**ANGEL PLACE  
LEVEL 8, 123 PITT STREET  
SYDNEY NSW 2000**

16 August 2019

## **SANTA SOPHIA CATHOLIC COLLEGE SSD 9772 – MINUTES OF MEETING 13 AUGUST 2019**

Figure 4 – Secondary Pickup Dropoff

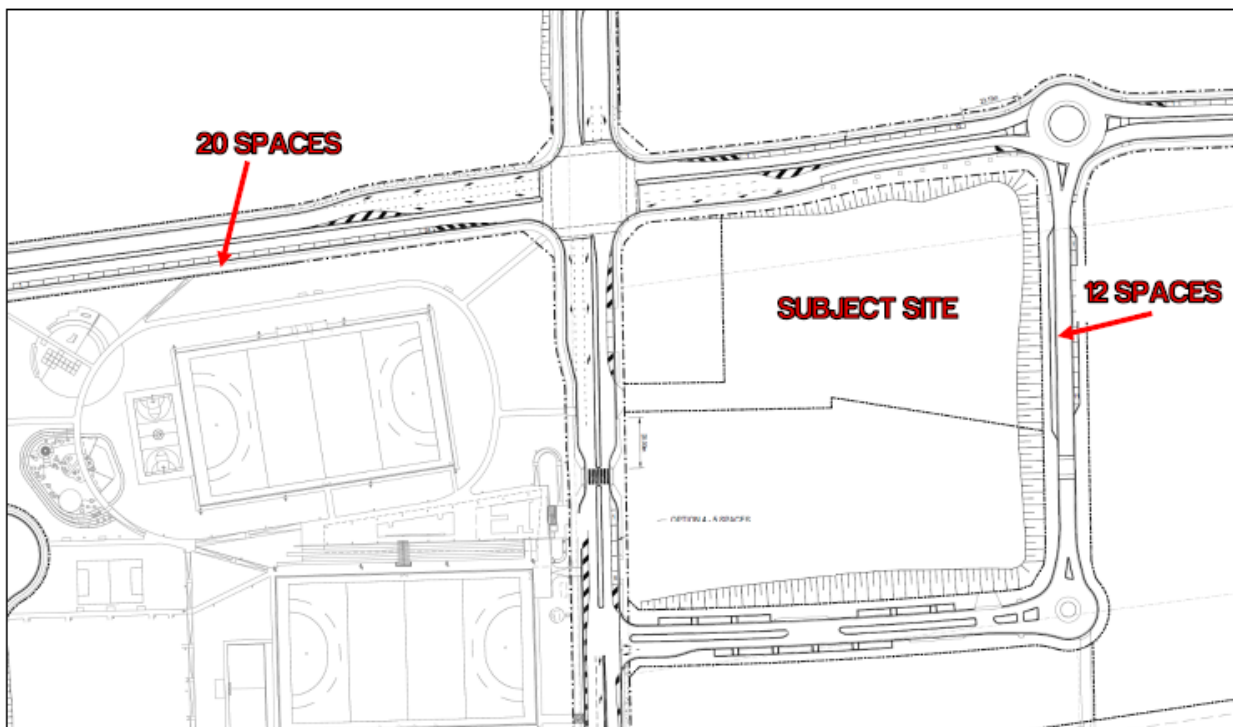
20. Council raised no issues with the temporary and permanent solution to parking.
21. Council commented that the roads must be built before the School opens and project team confirmed that this will be the case.
22. Council commented on the kiss-and-drop in Road B did not have 12 spots. Celestino to review and advise.
